**Applicants Responses to Relevant Representations at Deadline 1**

**RR-0220 – Further Response on behalf of Rhyl Flats Wind Farm Limited**

DRAWING NUMBER:004218003-11
APPF: 5 (2) (I)
Sheet No: 1 of 11
SCALE: 1:45,000 PLOT SIZE: A1 DATE: 05/08/1934 PROJECTION: BNG

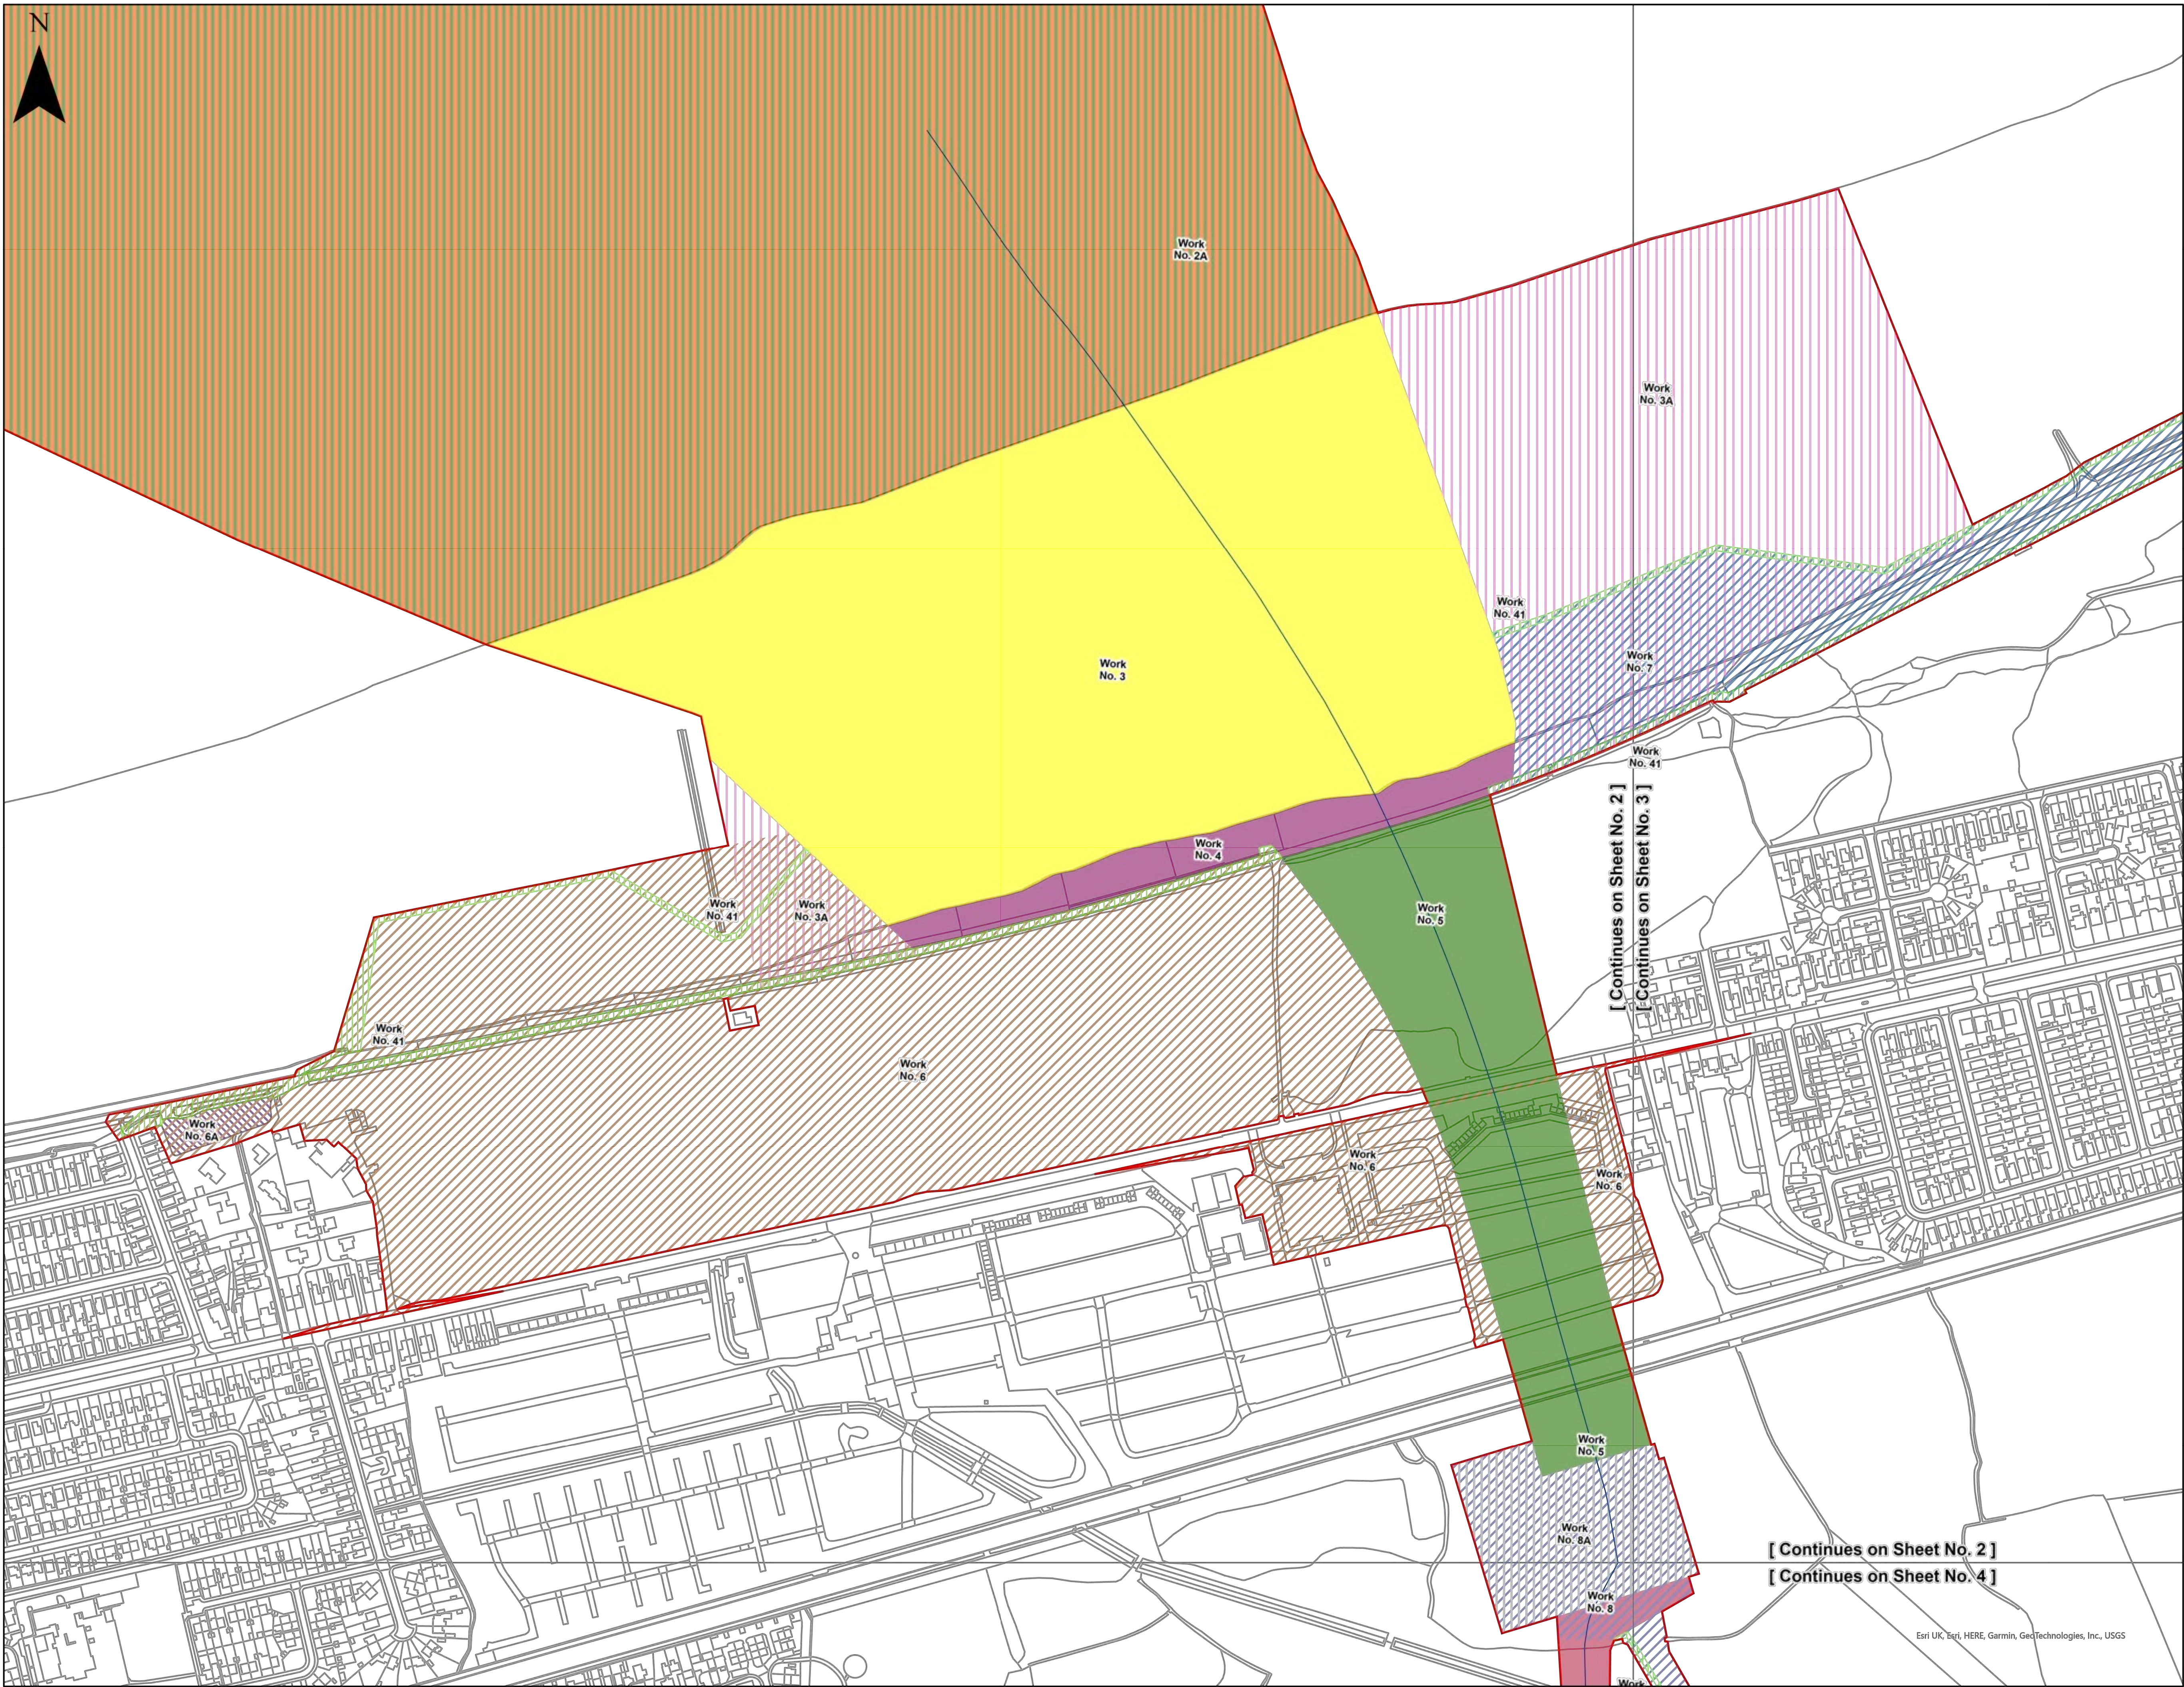
<p>this submission, the area within the RF Crown Estate lease should be excluded from the proposed development.”</p>	<p>before the close of DCO examination. Discussions are in progress.</p>	
RR-0020-2.2	<p>“2.2 The work plans show that Work No.2 also intrudes into the 250m restriction zone around the perimeter of the areas leased by the Crown Estate Commissioners to RFWFL for the operation of RF. The restriction zone exists to ensure that other proposed developments do not adversely affect the operation of RF. The Crown Estate Commissioners have covenanted with RF not to grant any lease, licence or consent (other than where the lease requires that RF’s consent is obtained) for the construction of any works within the restriction zone. RF has not been approached to provide such consent, representing an impediment to delivery of the scheme.”</p>	<p>The Applicant intends to resolve this by agreement with RFWFL at the earliest opportunity. Discussions are in progress.</p>	<p>Although the Applicant states they intend to resolve this matter by agreement, no proposals have been received by the Applicant and no discussions have taken place on this point.</p>
